21 February, 2018

RE: STAGE 1 DA (LOT 2) EASTERN CREEK BUSINESS HUB

1. As requested, we have reviewed the traffic matters raised by RMS, TfNSW, Blacktown Council and Planning and Environment with respect to the Stage 1 DA for Lot 2 within the Eastern Creek Business Hub. We prepared the traffic assessment for the Stage 1 DA (Eastern Creek Business Hub Stage 1 DA - Proposed Retail Centre Lot 2 – Traffic Report, September 2017). The matters raised and our response is set out below.

**12.5m LARGE RIGID VEHICLE  
 SWEEP PATHS**

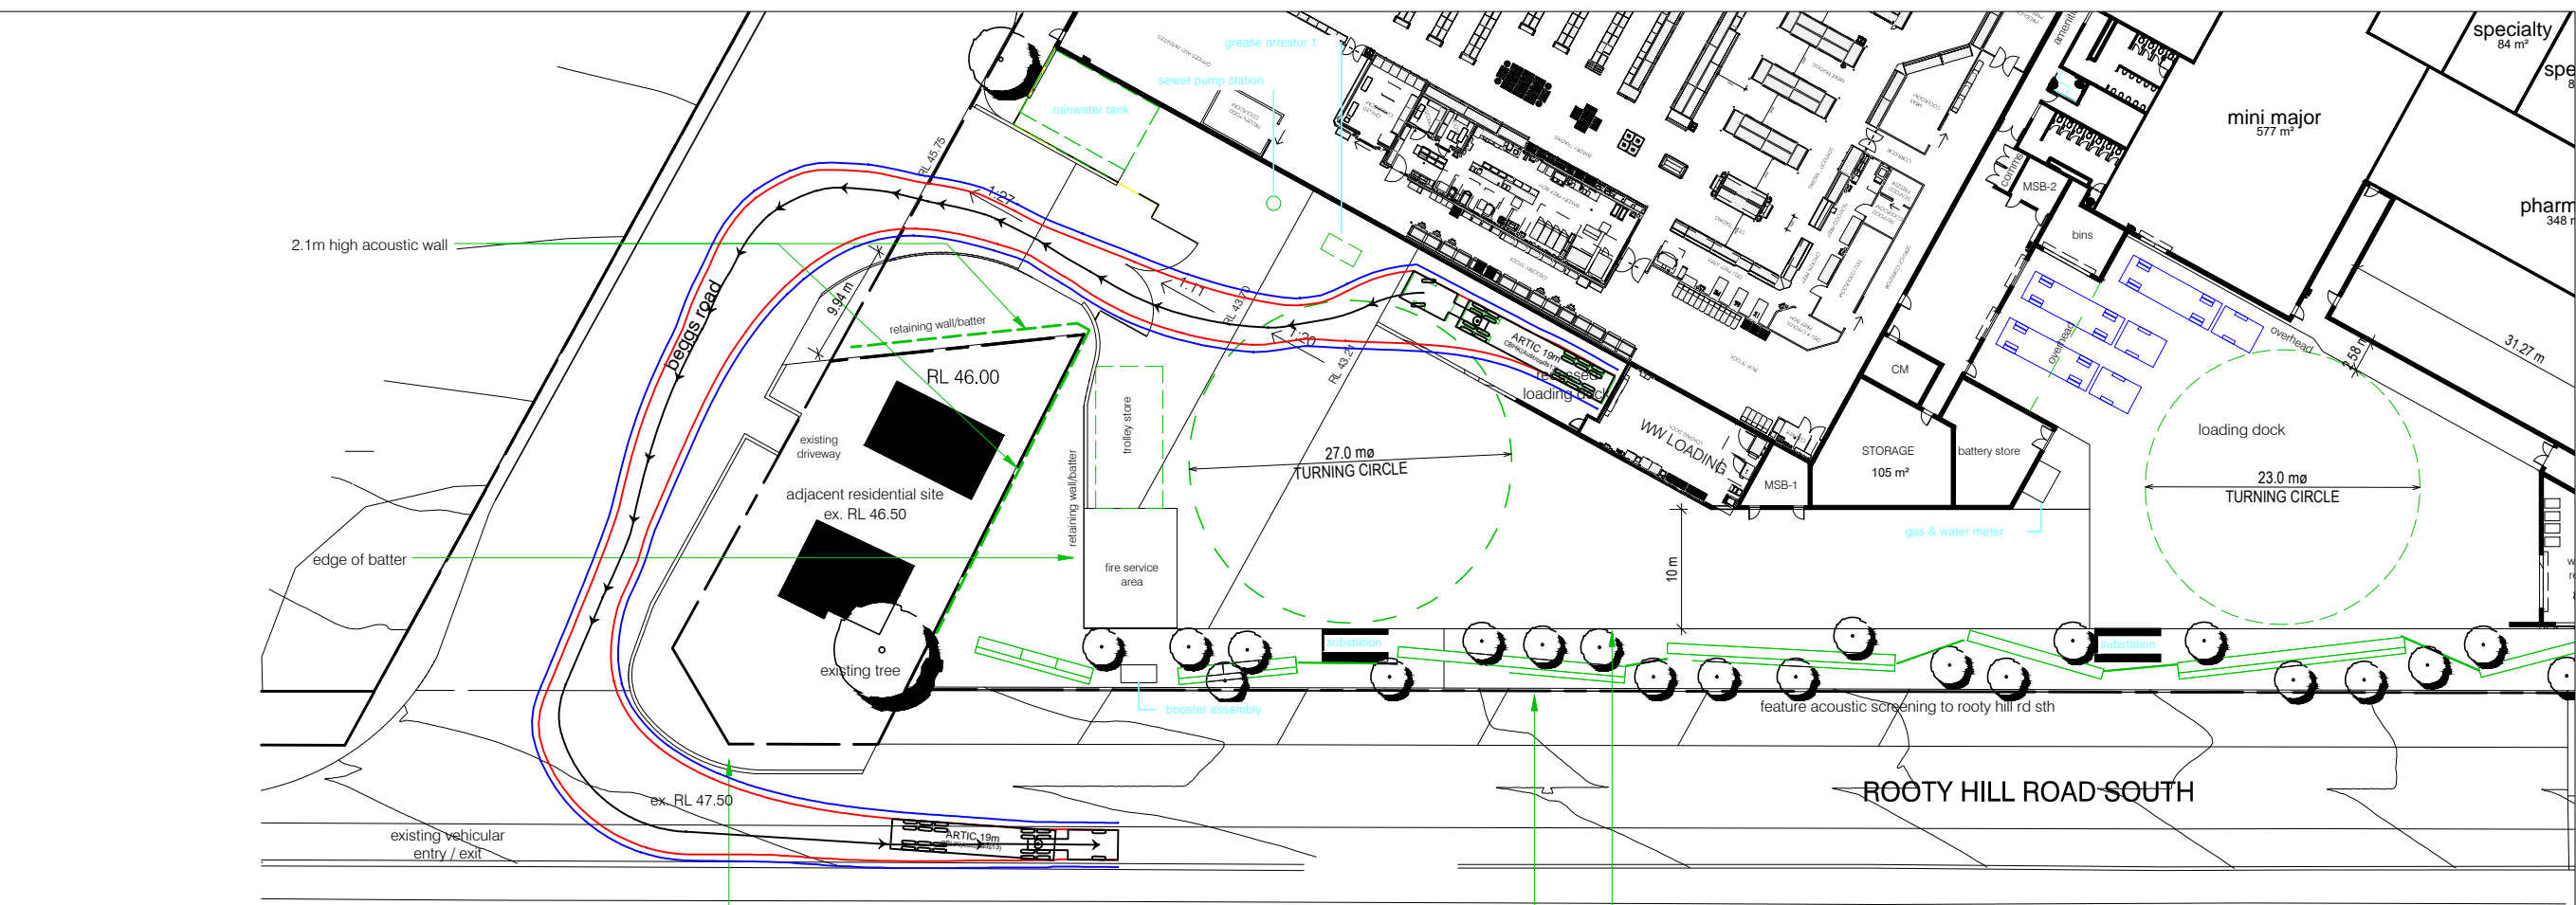
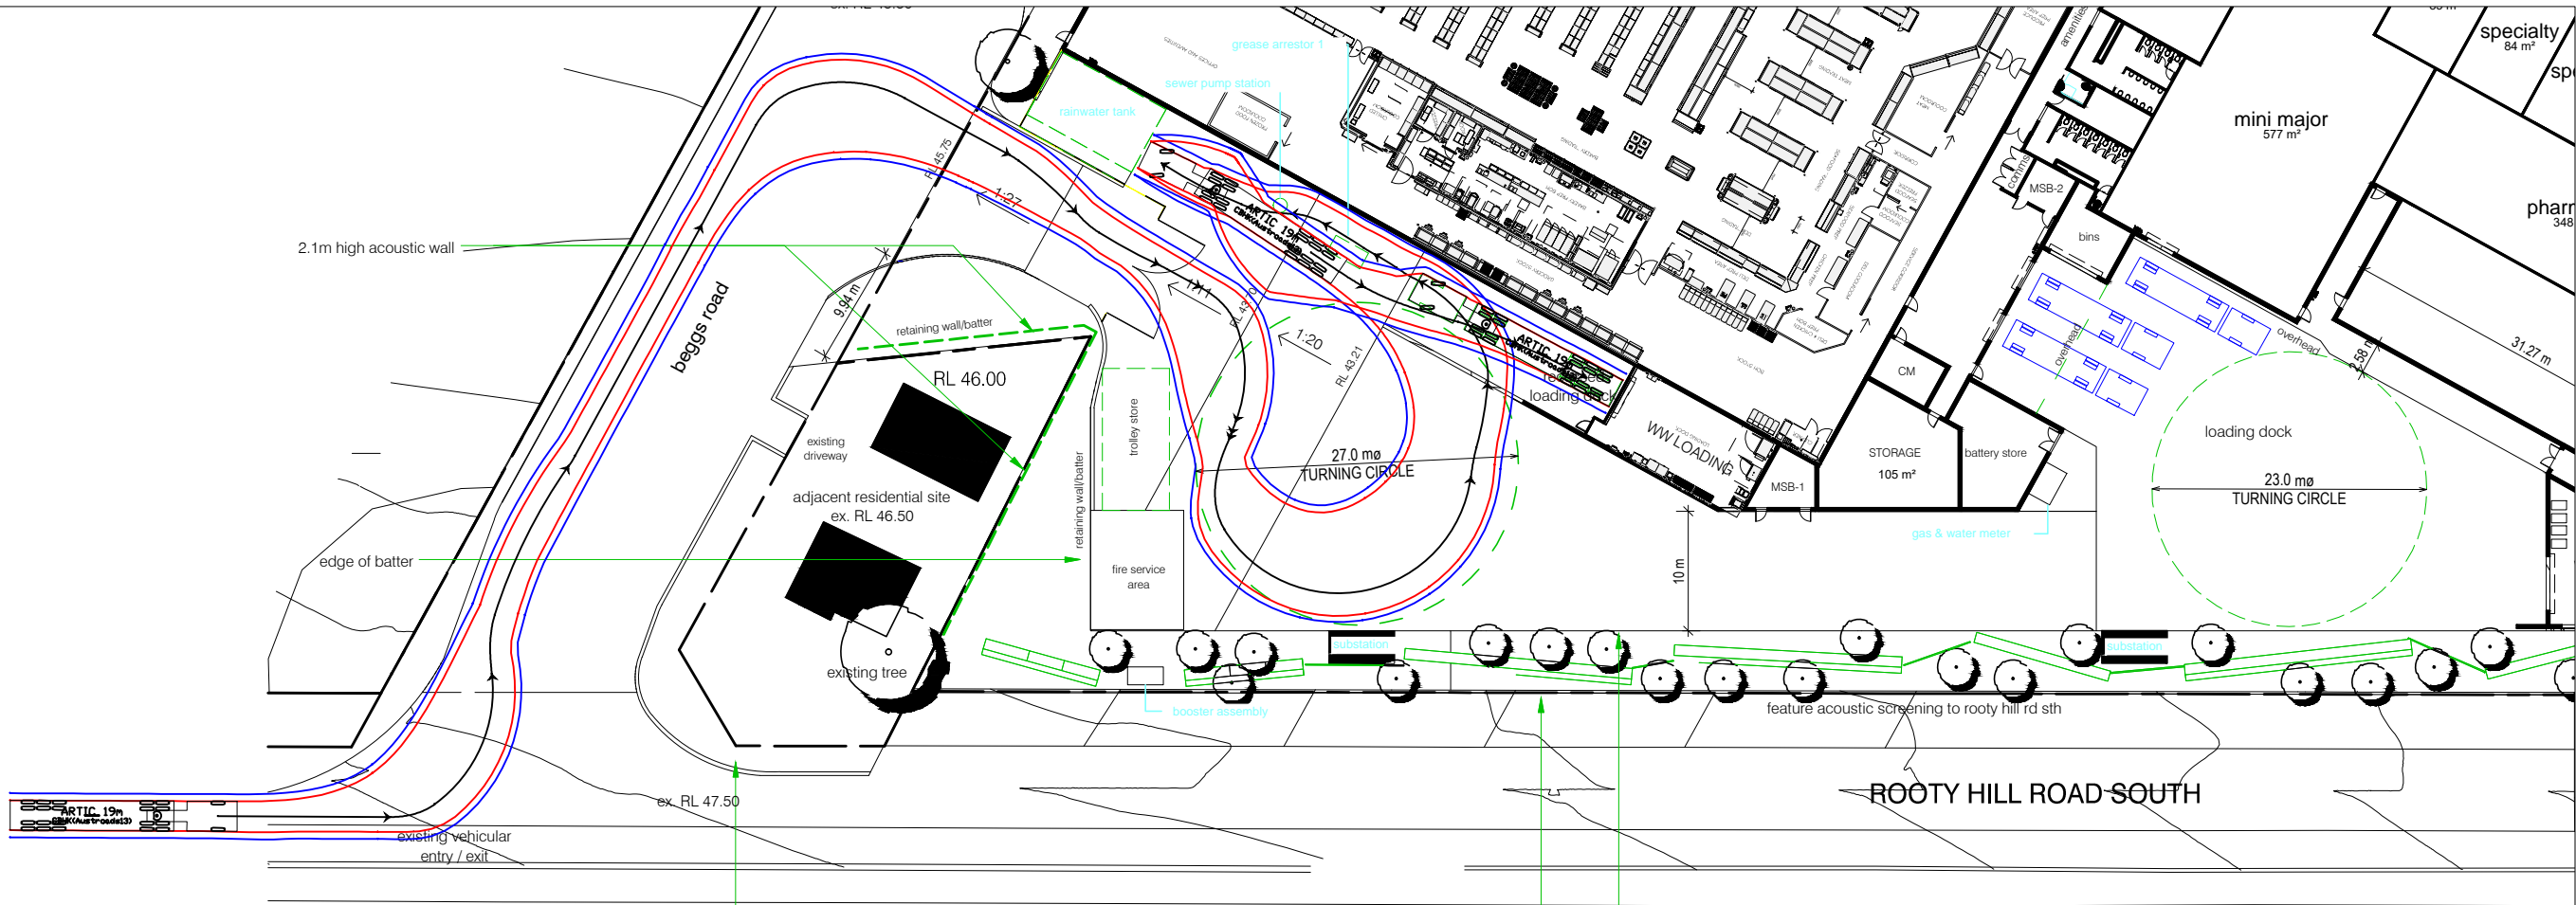
10. In its letter dated 29 November 2017, Council raised the following traffic matters:
 - Beggs Road should have a carriageway of 13.5 metres and a turning head in the form of a cul-de-sac with a 13.5 metre radius.

11. With regards to Beggs Road this will be a short dead end road of limited length (some 80 metres) providing service access to Stage 1 and access to the residential dwelling located on the southeast corner of Beggs Road and Rooty Hill Road South. As shown on the attached plan, the carriageway on Beggs Road has been widened to 13.5 metres. A turning head has been provided that allows a 12.5 metre long truck (including a garbage truck) to make a 3 point turn east of the access to the Stage 1 service area.

12. With regards to the request for a turning head in the form of a cul-de-sac with a 13.5 metre radius this cannot be provided within existing road reserve. It is also not warranted as:

- adequate turning area for a 12.5 metre long rigid truck has been provided (to turn in part of the road not accessed by the any vehicles) and thus to turn around in safely (without conflict to other vehicles);

- the volume of traffic using Beggs Road would be low (less than 10 vehicles per hour two way);
 - the need for a truck to turn around would be very low; and

- the turning area would allow a car to undertake a u-turn.
13. With regards to the other matters raised by Council we note that:
 - the proposed alignment of Beggs Road to Rooty Hill Road South (70 degrees) complies with Council's engineering standards;
